Project Name: **Old Barn Estates 16 Lot Subdivision**
Project ID: 2012-584; CBL: 414-A-4 (and part within Town of Falmouth)
Address: 1062 Ocean Avenue (Ledgewood Drive)
Applicant: Tim O'Donovan, TPO Properties LLC
Planner: Jean Fraser

On February 26th, 2013, the Planning Board considered the Level III Subdivision Review application for the Old Barn Estates 16 lot subdivision at 1062 Ocean Avenue (Ledgewood Drive). The Planning Board reviewed the proposal for conformance with the standards of the Subdivision Ordinance.

TO: Jean Fraser, Planner
FROM: David Senus, P.E.
DATE: February 20, 2013
RE: Final Level III Site Plan Application Response to Comments – Old Barn Estates

S-101

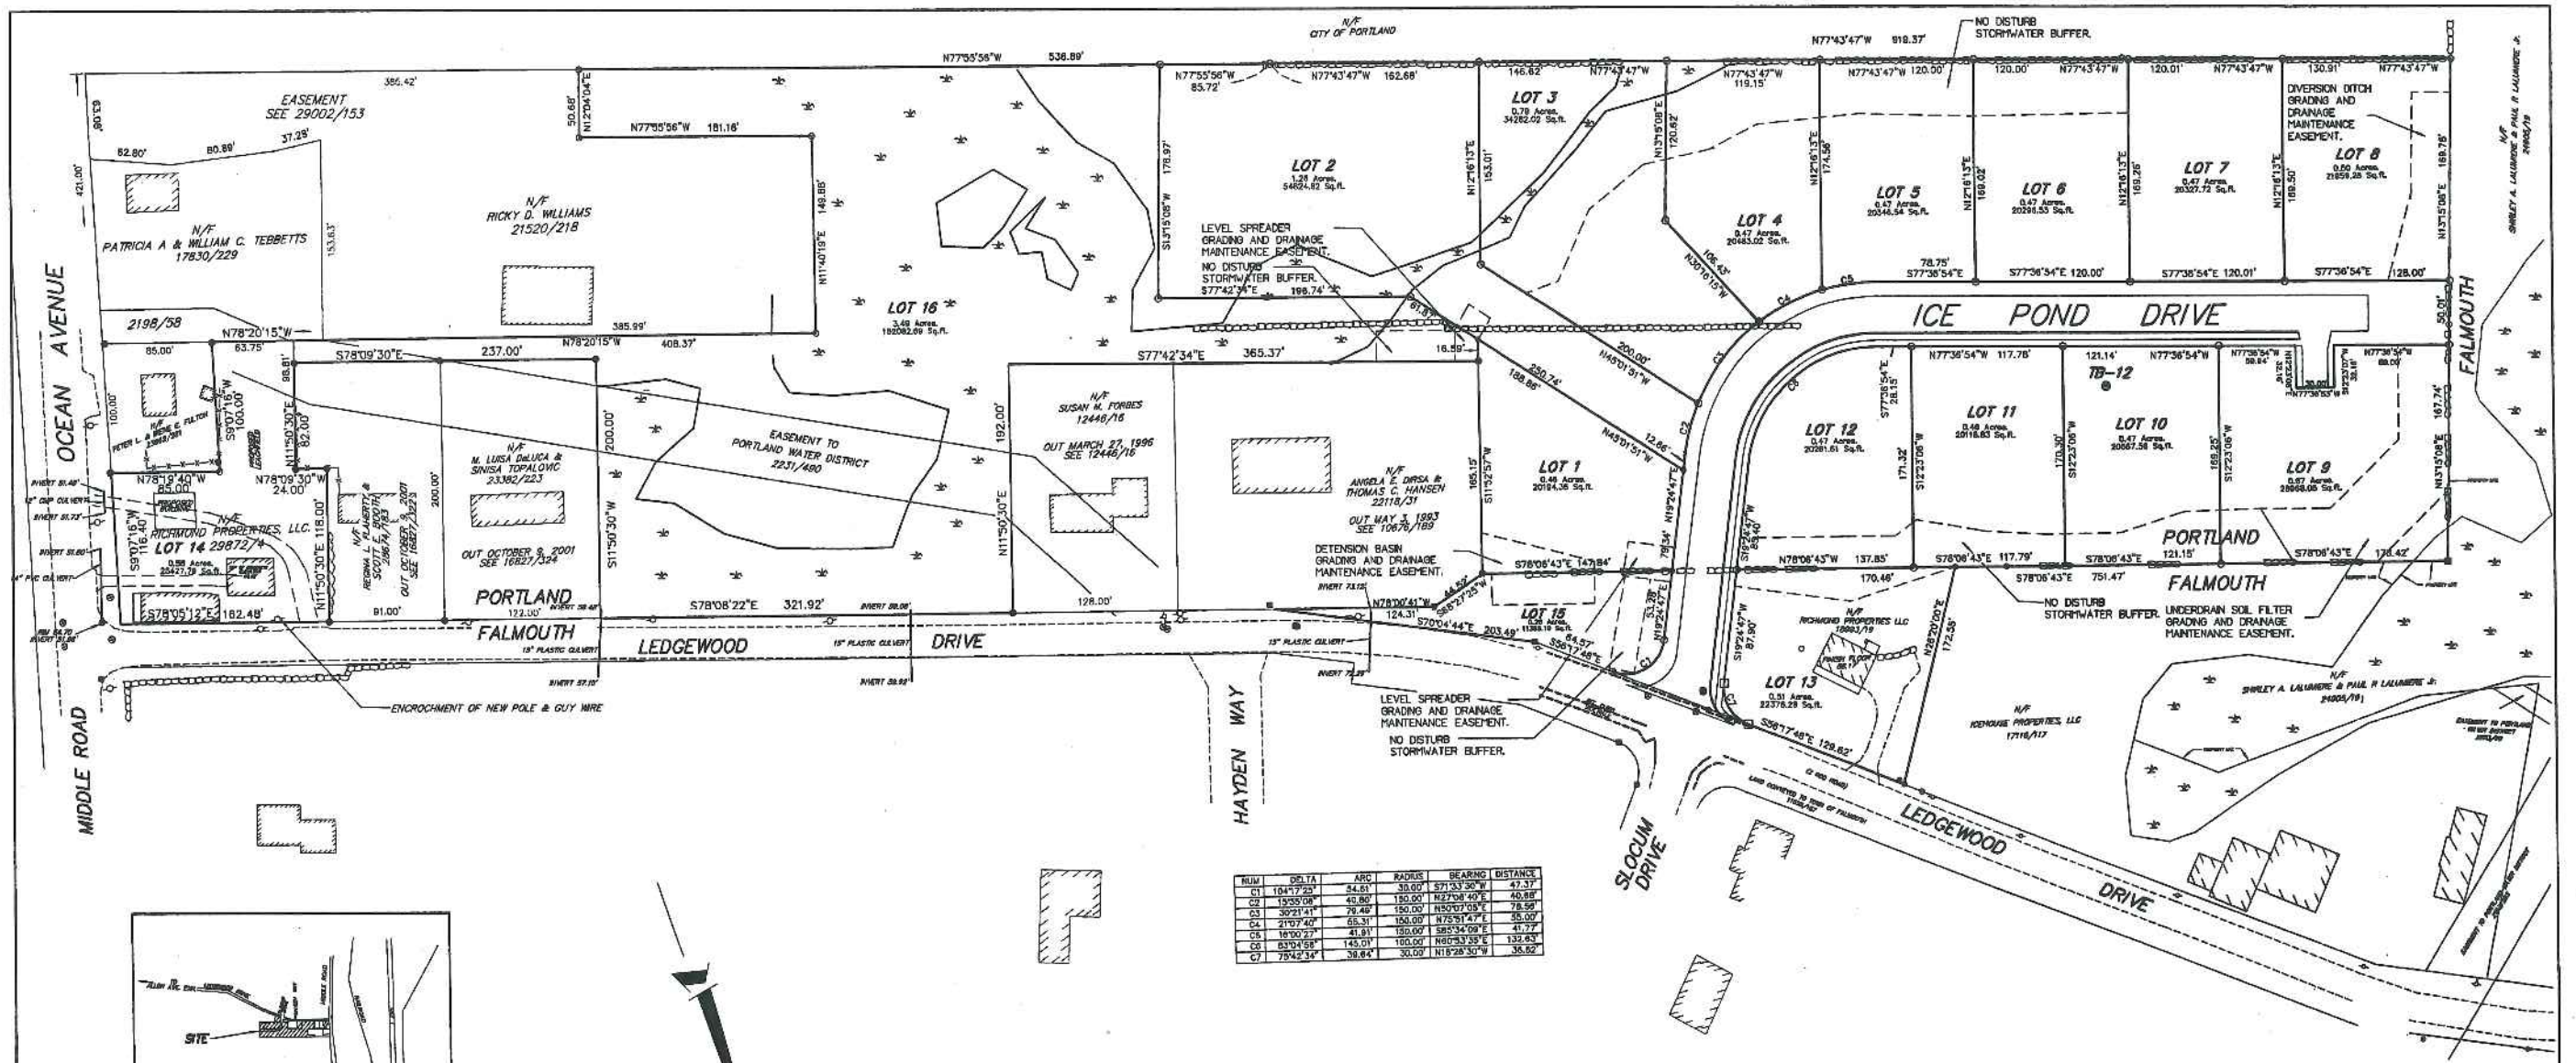
5. *Comment: Sheet S-101, Note 15 states that "Tree save areas and stormwater buffer areas shall be identified on the ground with capped rebar pins and signage as shown on Plan C-101"; however, C-101 does not specifically call out the rebar pins or signage.*

Although there appear to be symbols identifying the rebar pins and signage on C-101, these symbols are not identified within the plan legend or specifically called out on the plan. A callout for the pin and sign symbol should be added to C-101 (refer to the callouts used on S-101).

Applicant Response: Tree save and stormwater buffer areas are now identified on Plan C-101 showing location of rebar pins and signage. Also see note #15.
